File No: NTH24/00543/004
Your Ref: SSD-70748466 - PAE-100162207

Advice on Assessment for Huntlee New Town - Stage 2 - Wine Country Drive, Rothbury

SSD-70748466 - Advice on RTS - Huntlee New Town - Stage 2 - Wine Country Drive Rothbury

RE: Review of Environmental Impact Statement (SSD-70748466) - Advice on EIS - Huntlee New Town - Stage 2 - Wine Country Drive Rothbury

DRAWING TITLE
CONCEPT CIVIL
ENGINEERING PACKAGE
INTERSECTION A-11 - VEHICLE
SWEPT PATHS PLAN - SHEET 2

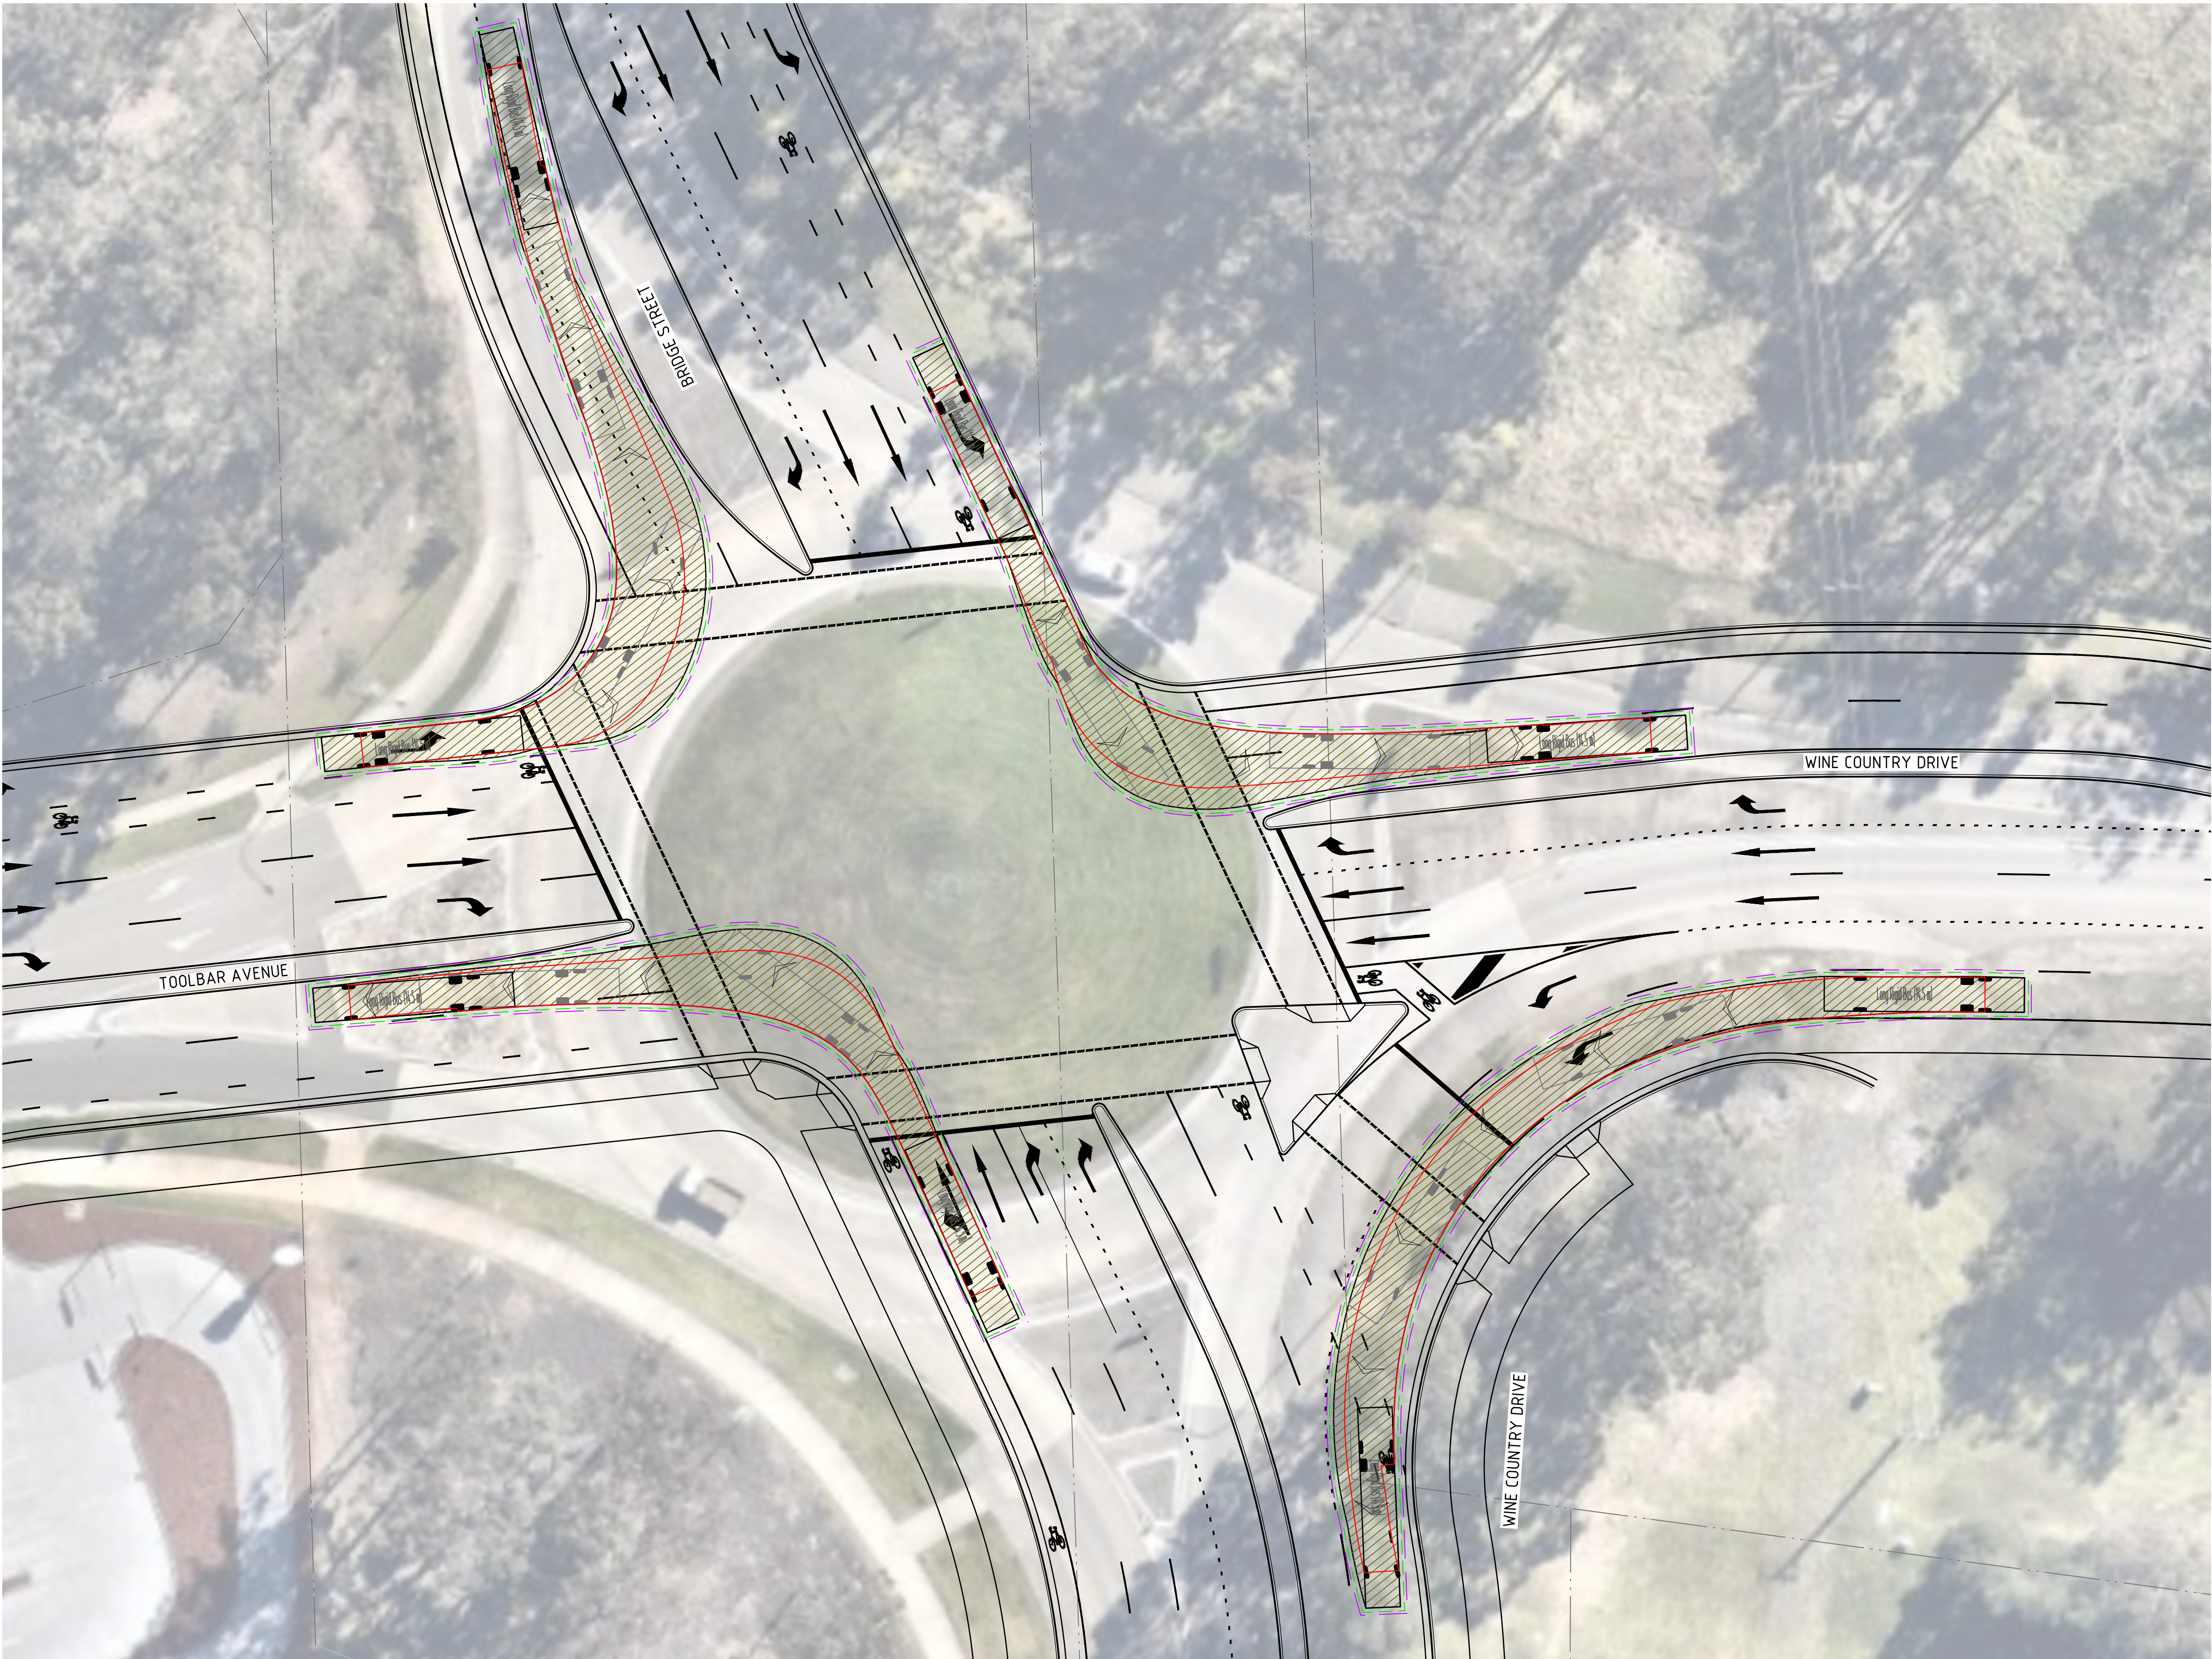
1. Intersection A-11 was identified in the TfNSW response to the EIS on **15 August 2024**, advising *'comment is sought on the northern approach which currently has a 95% queue of 311.8m in the PM Peak'*. This demonstrates a Level of Service (LOS) F which cannot be accepted.
2. On **8 August 2025**, in response to the RTS, TfNSW noted *'In previous correspondence dated 15 August 2024, further justification was sought as to the significant queue lengths anticipated at Intersection A-11 (the northern approach for the Hunter Expressway in the PM peak).'*

- SIDRA model - Inputs in the revised SIDRA model require further attention / comment. Maximum cycle times should be 120 seconds.
- SIDRA (A-11) – Further comment is sought on the northern approach which currently has a 95% queue of 311.8m in the PM Peak. This is the situation with the identified upgrade in place.

1. Sensitivity testing of the modelling be undertaken to identify the number of lots that could be released prior to unacceptable impact on the intersection (LOS C or D as minimum), which could then be conditioned, and/or
2. An appropriate upgrade solution be determined for the total number of lots so that it may be conditioned, with a view to providing flexibility in the condition for further modelling to inform an alternative upgrade solution, if appropriate, to the satisfaction of TfNSW.

DRAWING TITLE CONCEPT CIVIL ENGINEERING PACKAGE INTERSECTION A-8 - VEHICLE SWEEP PATHS PLAN - SHEET 2

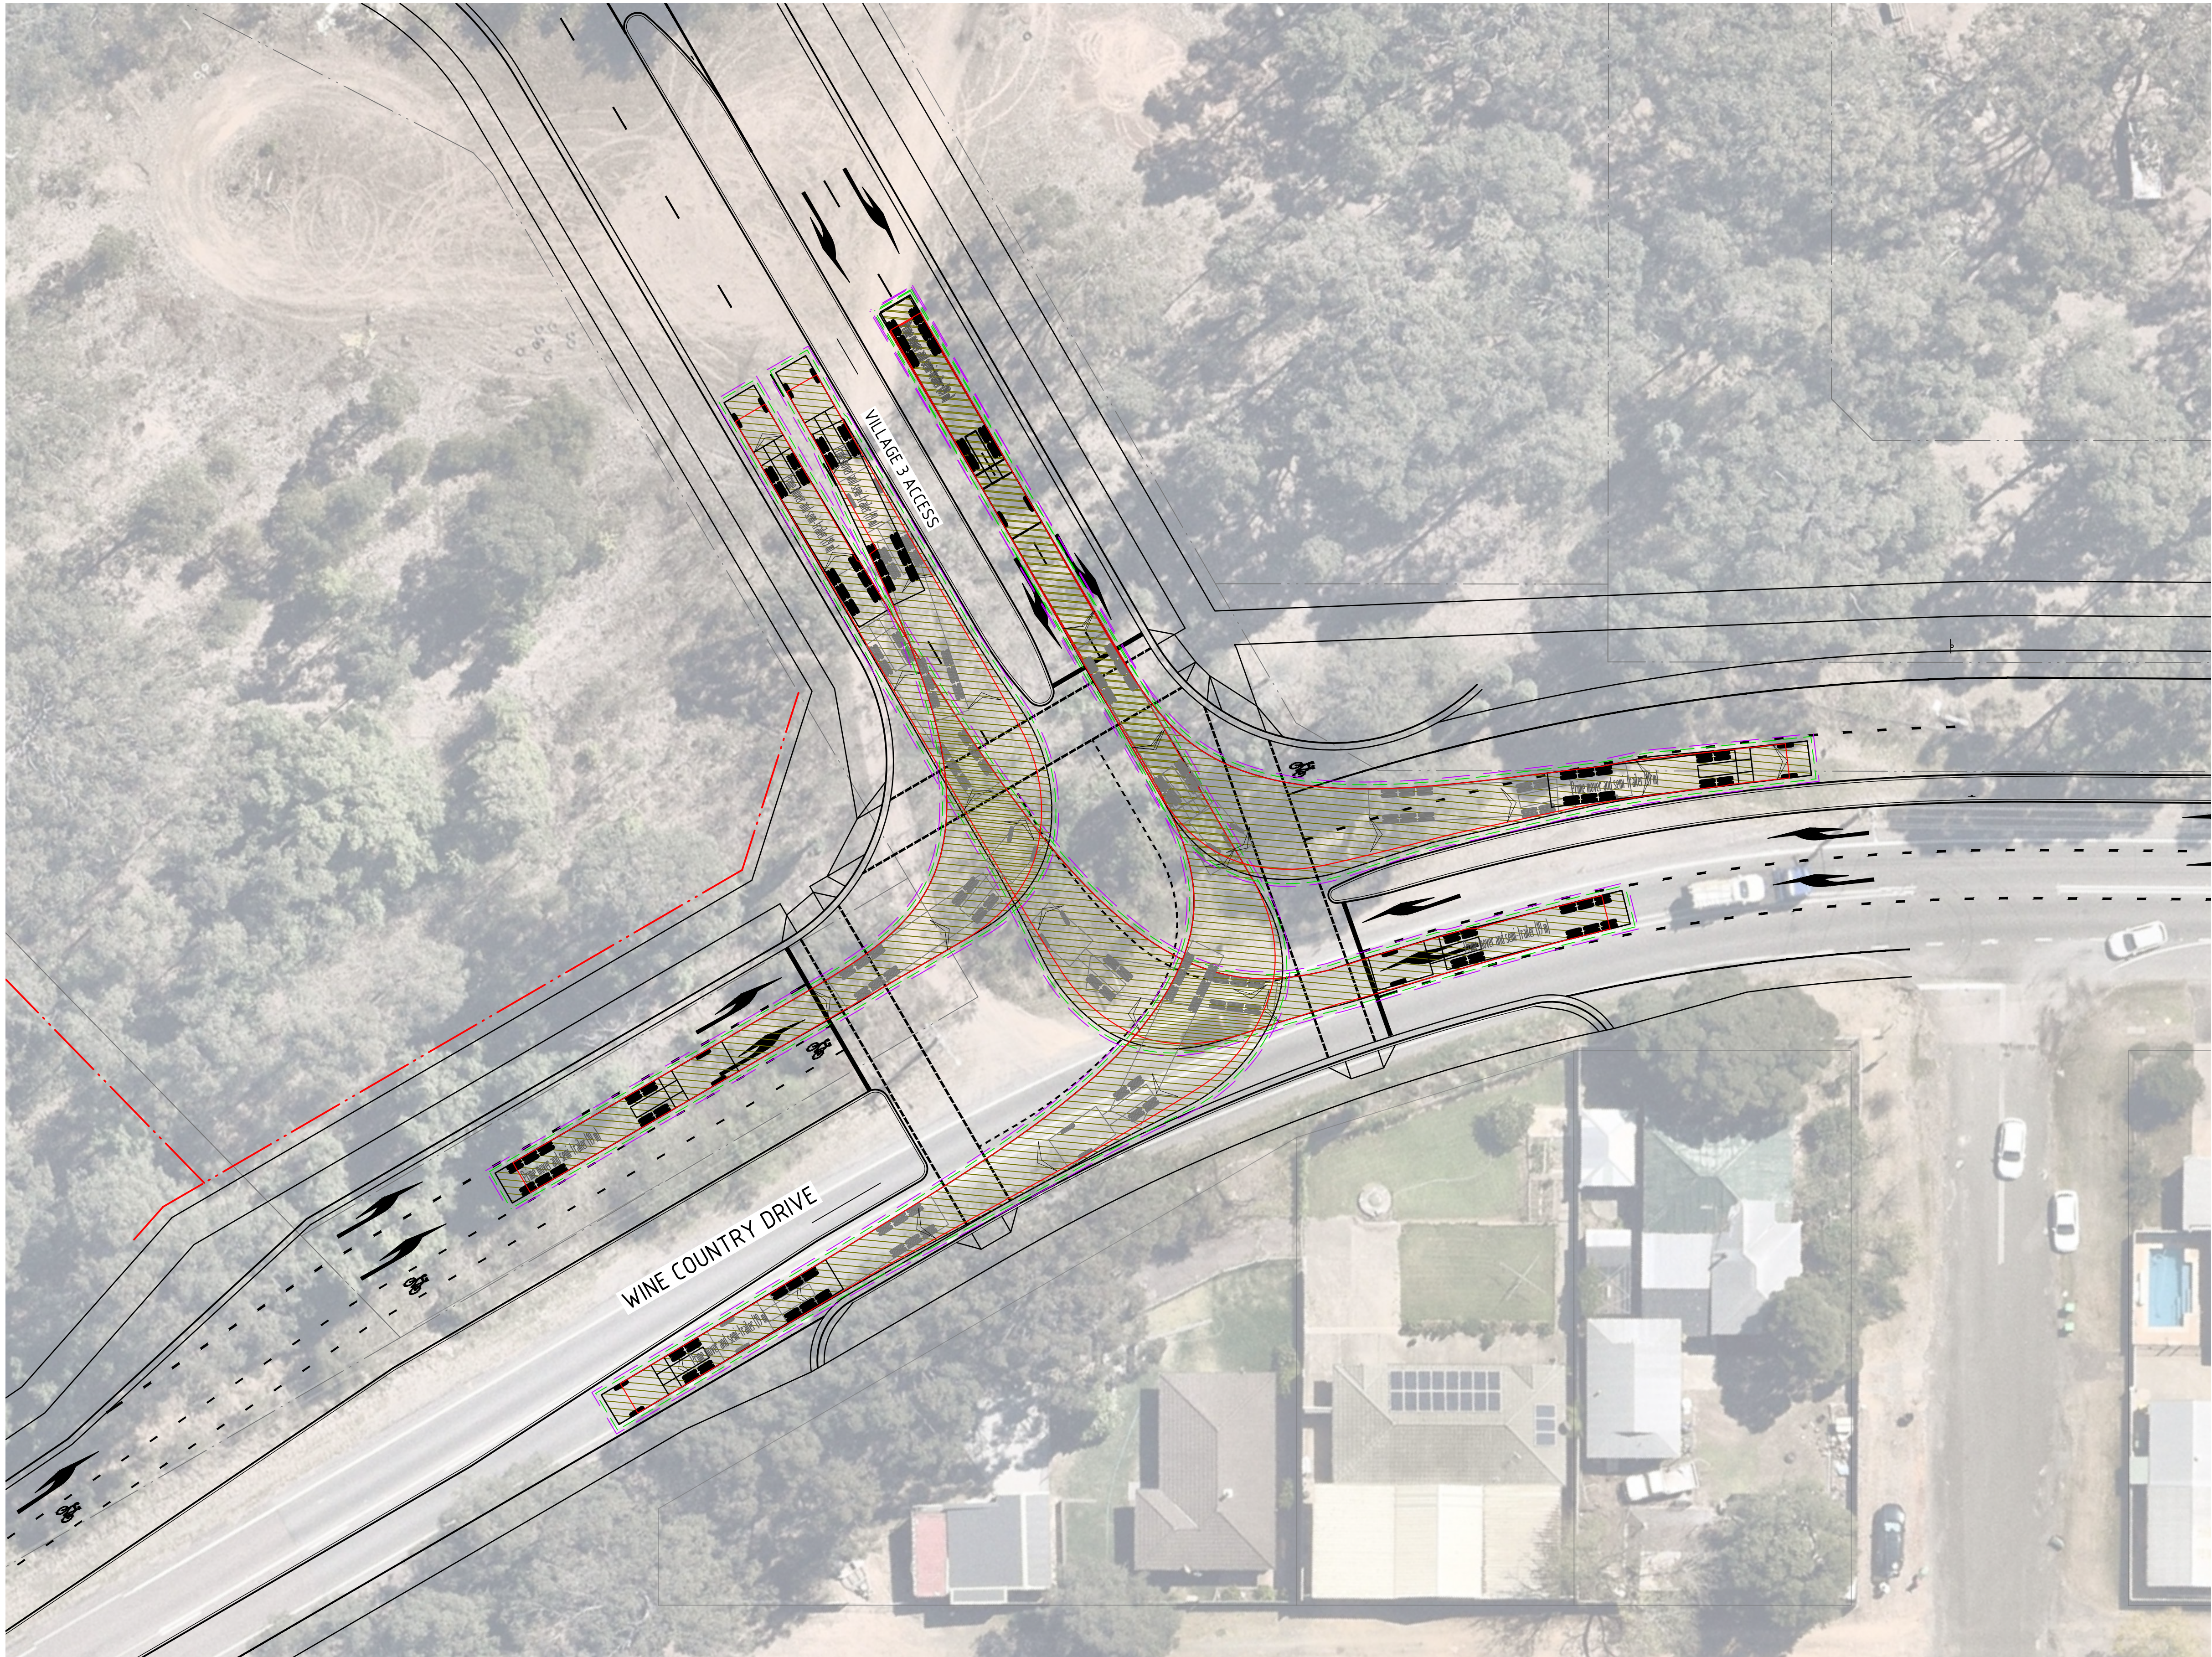
- Intersection A-8 – Further comment is sought on this intersection. Currently, the lots on the eastern side of WCD (Reid Street & Mayne Street) have opportunity to turn right in and right out. The proposed TCS will not permit them to make this movement. Also, the original Hyder report identified this intersection as a new roundabout in the full Huntlee development.
